The Drovers Solar Farm

Statement of Common Ground (SoCG) with Environment Agency (Clean)

PINS reference: EN0110013

Document reference: APP/5.13.1 (Revision 1)

DRAWING TITLE:
Figure 12.14: Work No. 3 Maximum Potential Foundations and Groundwater Elevations

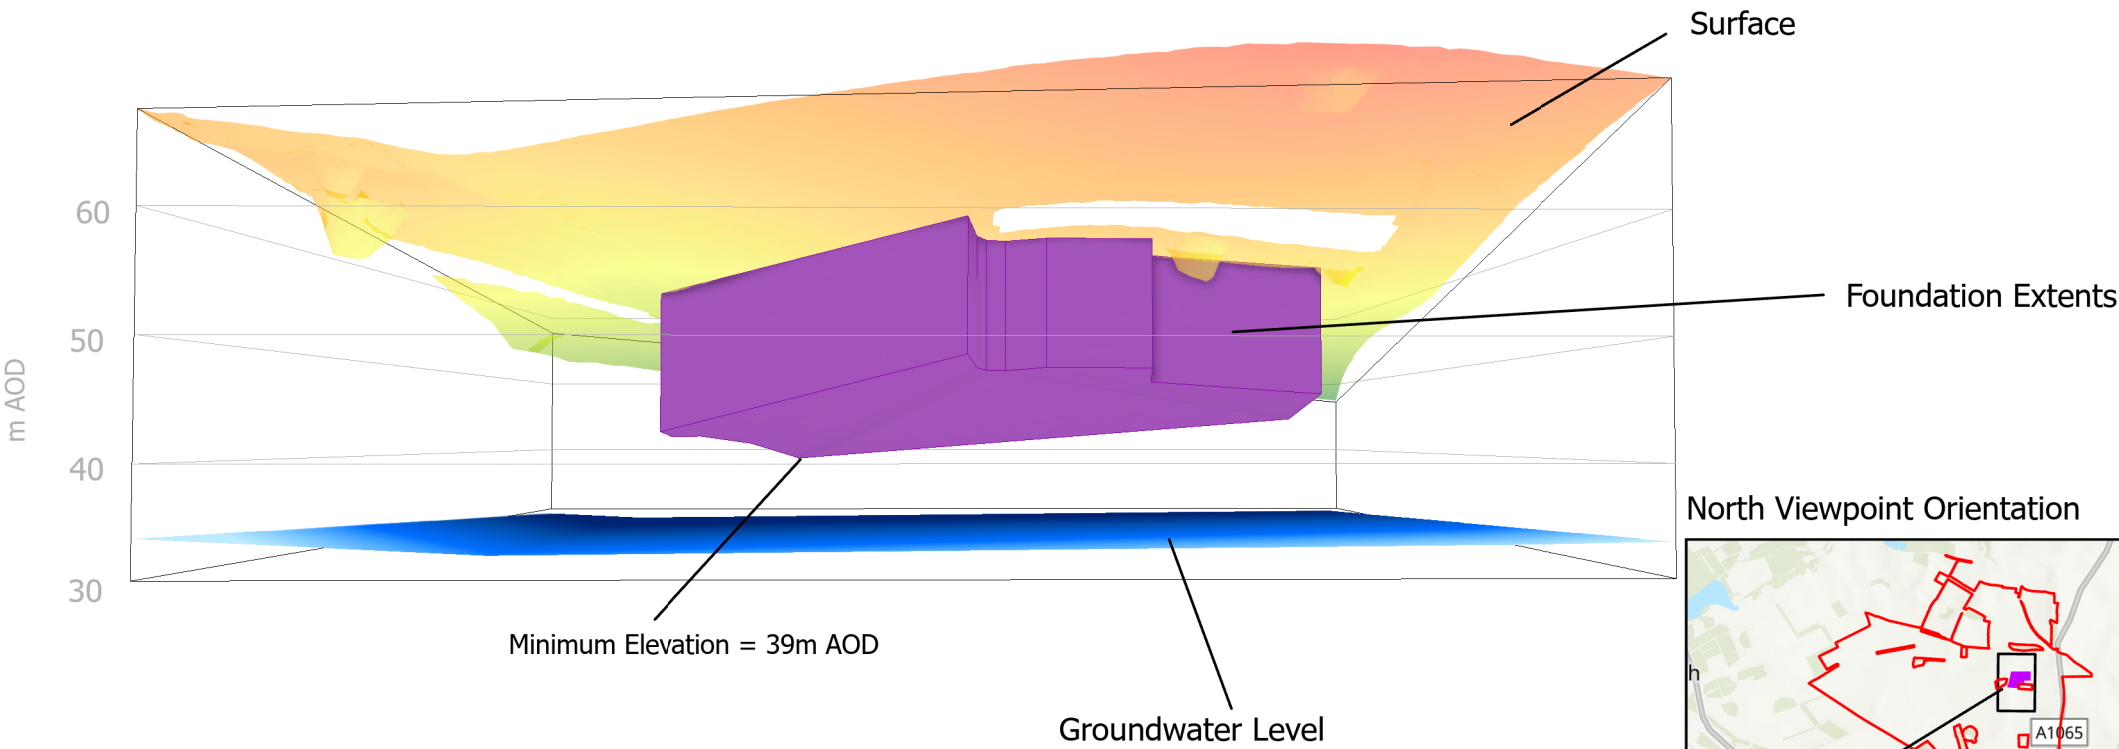
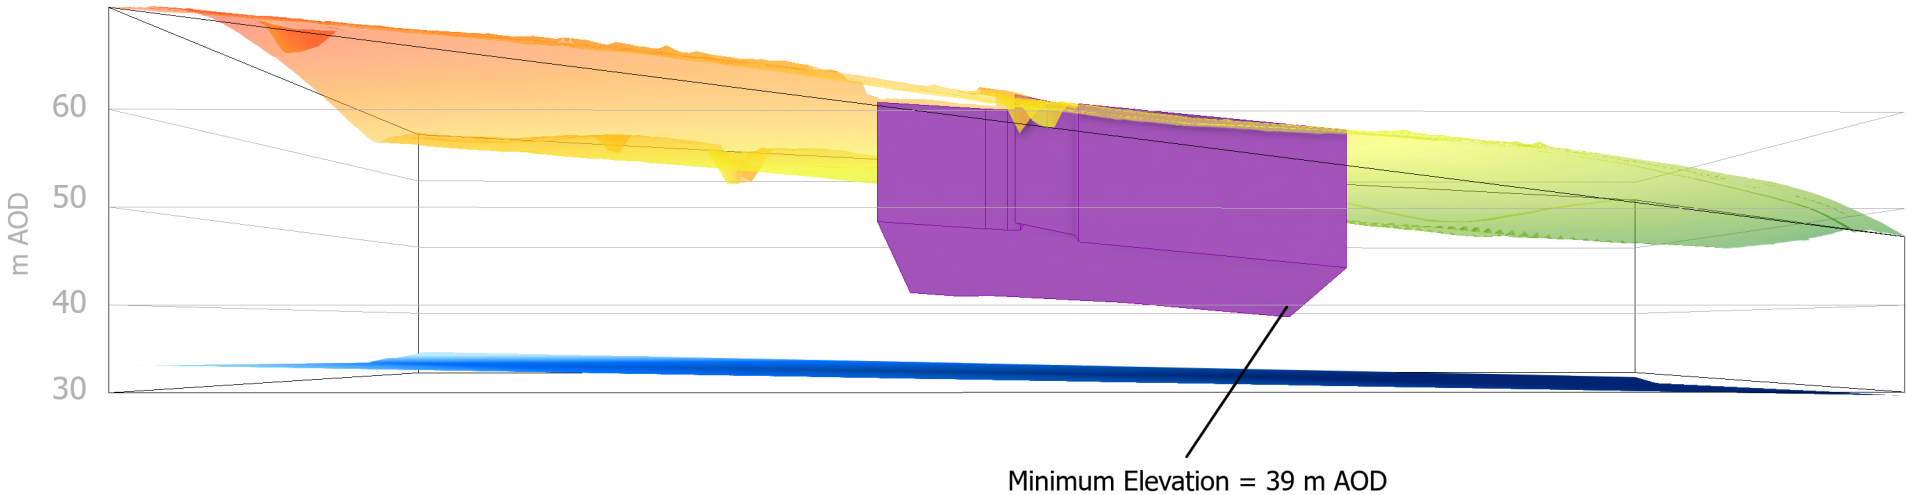
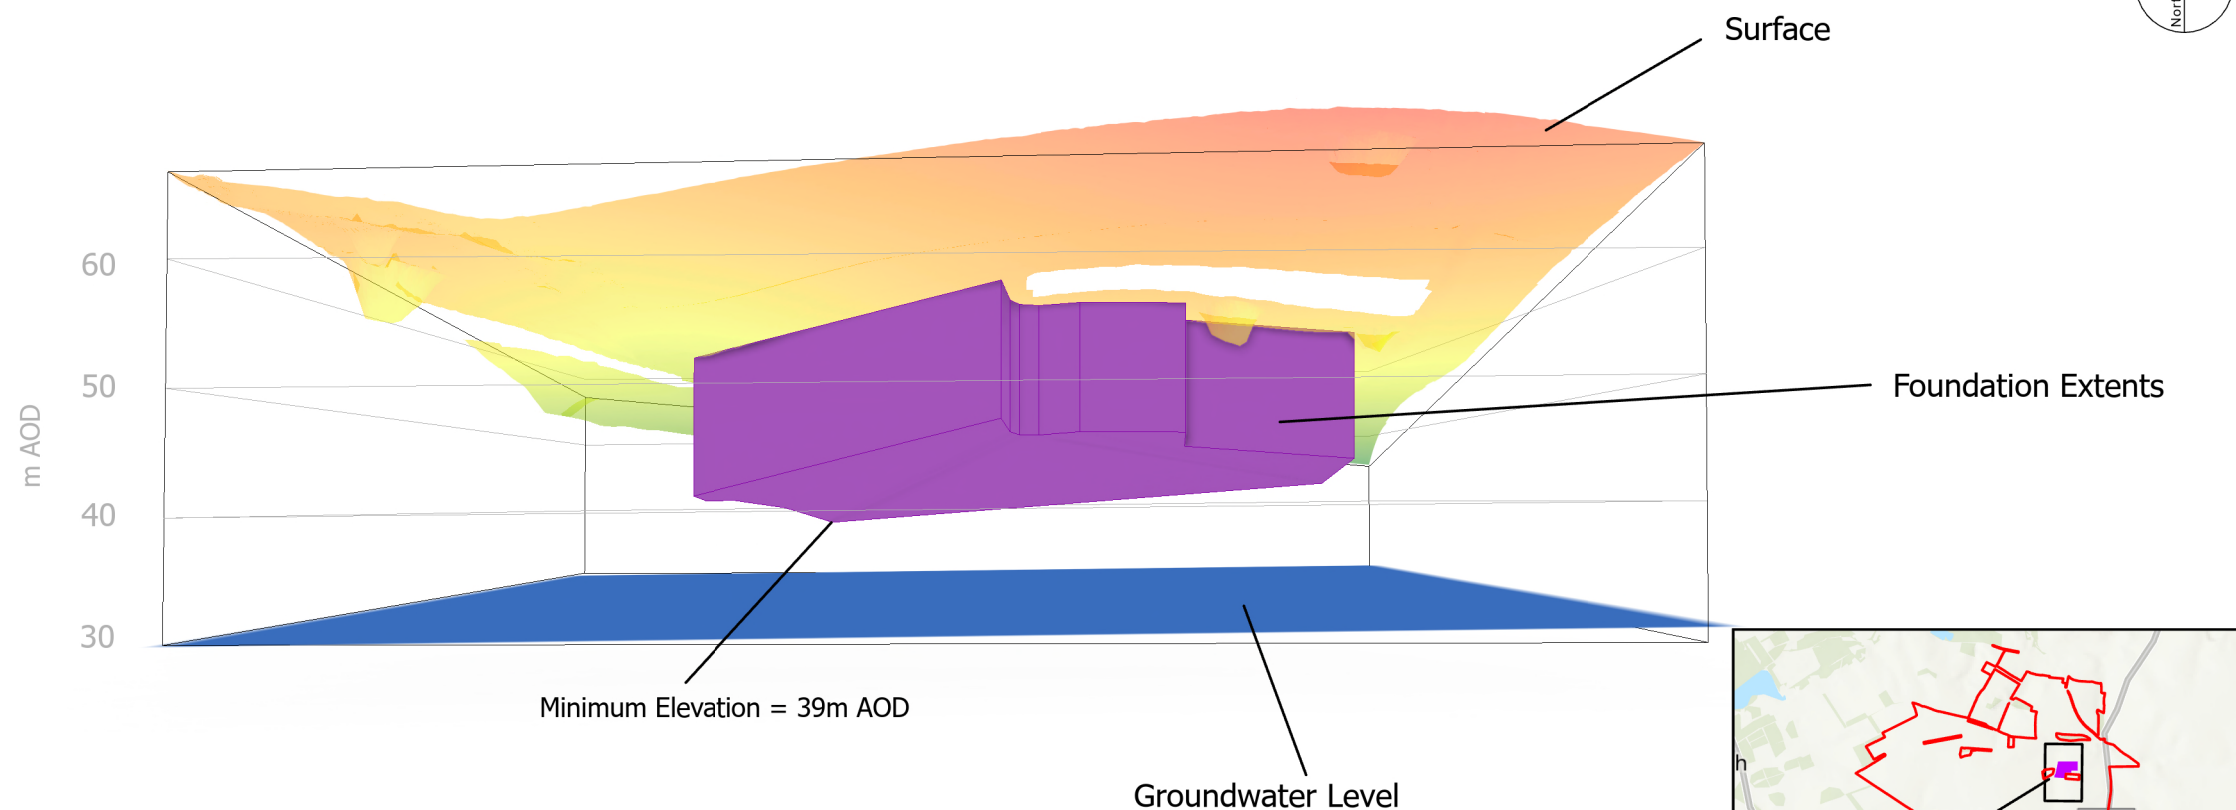
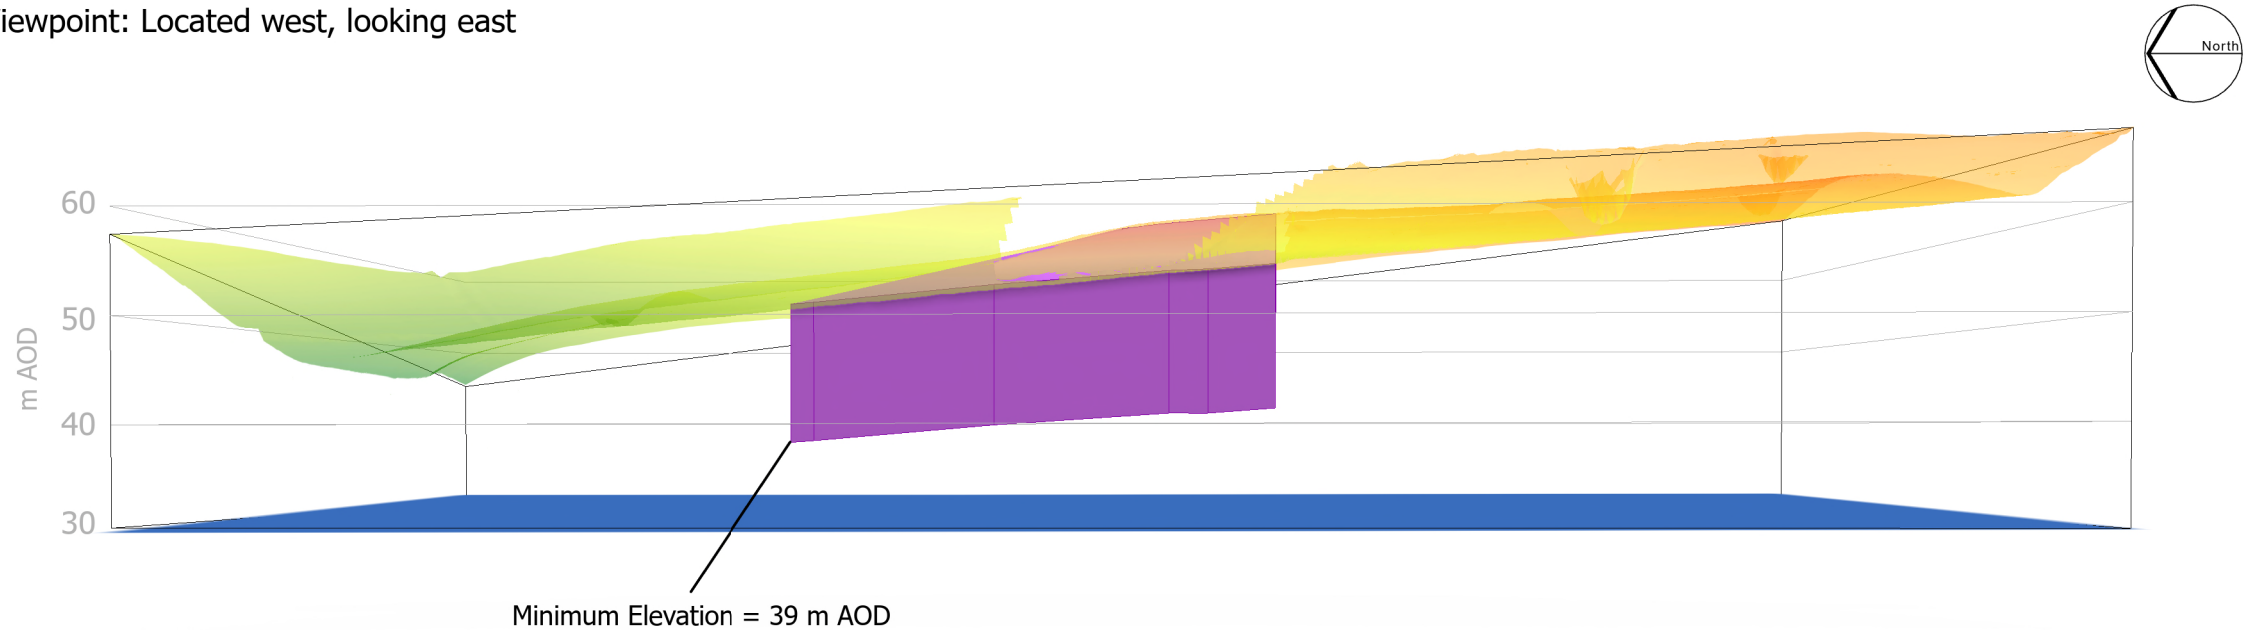
Reference	EA Issue Reference	Topic	Consultee's Position	Applicant's Position	Status
2-1	EA05	Maximum Foundation Extents	Figure 12.13 Work No.2 Piling Locations within CSA for Maximum Groundwater Level [APP-127] Figure 12.14 Work. No 3 Piling Locations within CSA for Maximum Groundwater Level [APP-128] Figure 12.15 Work No. 4 Piling Locations within CSA for Maximum Groundwater Level [APP-129] Figure 12.16 Maximum Foundation Extents for Minimum Groundwater Level [APP-130] Issue: Figures 12.13 to 12.16 do not clearly show the orientation of each 3D model view,	Figures 12.13 to 12.16 of ES Chapter 12: Water Resources [APP-061] were used to illustrate the maximum groundwater elevation surface across the Core Study Area and identify where proposed foundation depths could theoretically intercept shallow groundwater under worst-case conditions. The figures also demonstrate at a concept level where piling may be required depending on foundation design. The following changes have been made at Deadline 3 to aid the EA's interpretation: Addition of orientation labels or description	Medium

and the elevation of the maximum extent of foundations is not given. Impact: Difficulty in interpreting figures. Solution: Revise figures to more clearly define the area represented in the drawings, including view orientation, and the maximum foundations extent should be shaded to show elevation values. The model should be updated to inform detailed foundation design, based on site specific survey and monitoring data. Additional Comments: Use of inconsistent terminology may also result in confusion. Figures 12.13 to 12.15 are titled to show the anticipated extent of piling in comparison with the maximum groundwater level. In the context of the data presented, the maximum groundwater level in mAOD represents the shallowest extent and therefore worst-case condition for groundwater. For clarity the report should preferably refer to groundwater 'elevation' (in mAOD) as is represented within the figures rather than 'level', which could be misinterpreted as relative to ground level rather than Ordnance Datum. Figure 12.16 shows the minimum (i.e. deepest) groundwater elevation (i.e. best case) in relation to anticipated piling depth. Although this is useful information, this could potentially be misinterpreted by the reader as presenting a combined overview of the	- Elevation shading to show mAOD values for the maximum groundwater elevation surface and foundation extent surface - Highlight areas where foundations intersect or exceed groundwater elevation surfaces; and - Figures and text refer to groundwater elevation (mAOD) rather than groundwater level to increase clarity between absolute elevation and depth below ground. The Applicant agrees that the conceptual model present is not the final tool for foundation design, but rather to provide a screening-level assessment of groundwater conditions and to identify areas needing piled or shallow foundations and will be aligned with EA regional groundwater understanding (NEAC model). The Design Principles, Parameters Commitments [APP/5.8.3] have been updated at deadline 2 to commit to foundations not directly interacting with groundwater.
